Application by Mona Offshore Wind Limited for Mona Offshore Wind Farm
The Examining Authority's written questions and requests for information (ExQ1)
Issued on 13 September 2024

The following table sets out the Examining Authority's (ExA's) written questions and requests for information - ExQ1. If necessary, the examination timetable enables the ExA to issue a further round of written questions in due course. If this is done, the further round of questions will be referred to as ExQ2.

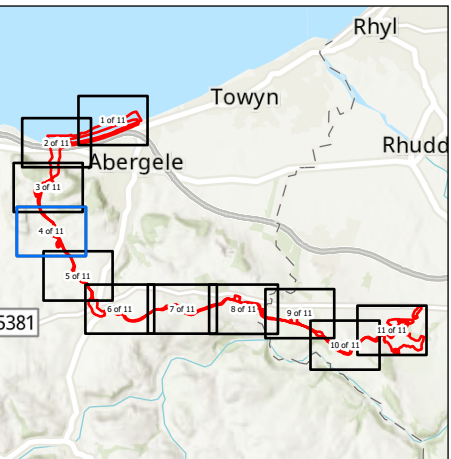
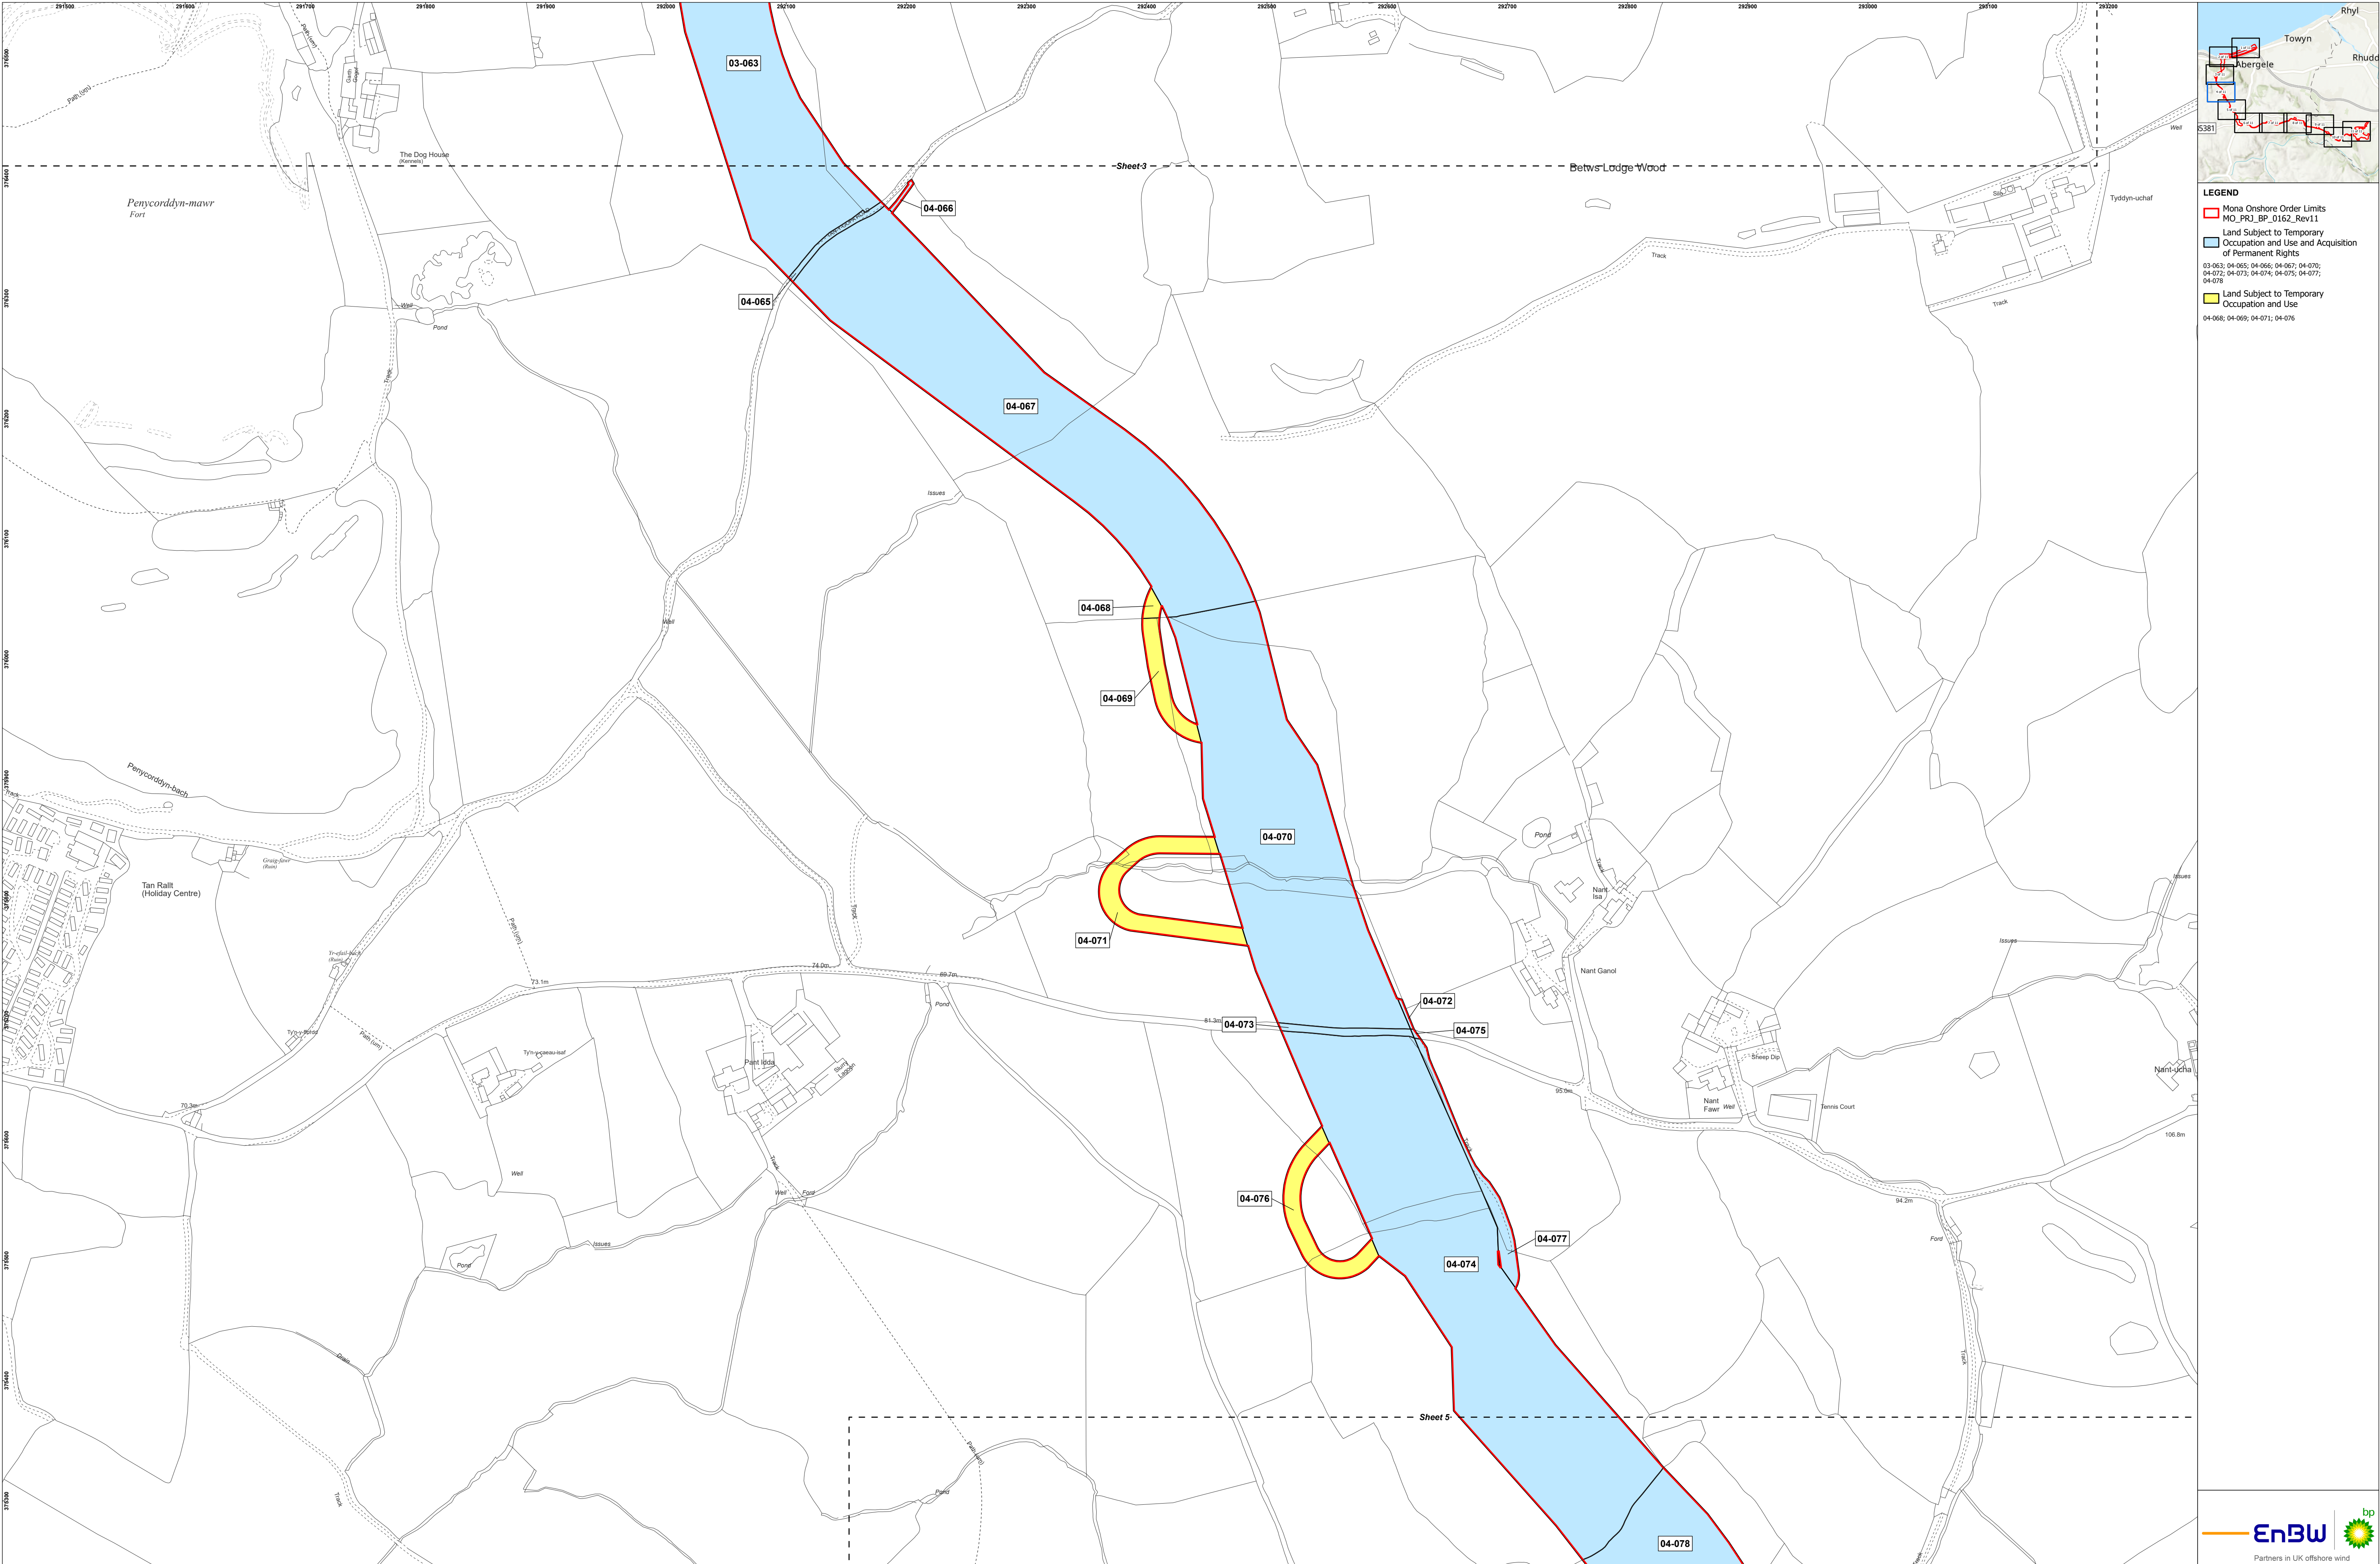
ExQ1	Question to:	Question:
		Can you confirm that you have a legal interest in the following plots shown in the BoR [REP2-008] and Land Plan (Onshore) [REP1-004]: 04-069, 04-070, 04-071, 04-072, 04-073, 04-074, 04-075, 04-076 and 04-077?
Q1.6.3	Hefin Williams	BoR Does the BoR [REP2-008] need to be changed to correctly reflect your legal interest in land subject of the Proposed Development? If so, how?
Q1.6.4	Lois Williams	BoR Does the BoR [REP2-008] need to be changed to include land within the Order Limits of the Proposed Development, as shown on the Land Plan (Onshore) [REP1-004] or the Works Plan – Onshore [AS-003], in which you have a legal interest? If so, how?
Q1.6.5	G Lloyd Evans & Sons H L & RJL Evans	BoR Does the farm subject of your written submission [REP2-103] comprise only land in the BoR [REP2-008], and shown on the Land Plan (Onshore) [REP1-004], that is registered to Robert John Lloyd Evans? If not, please list the Plot Nos. that are comprised within the holding and/or annotate an extract from the relevant Land Plan(s).
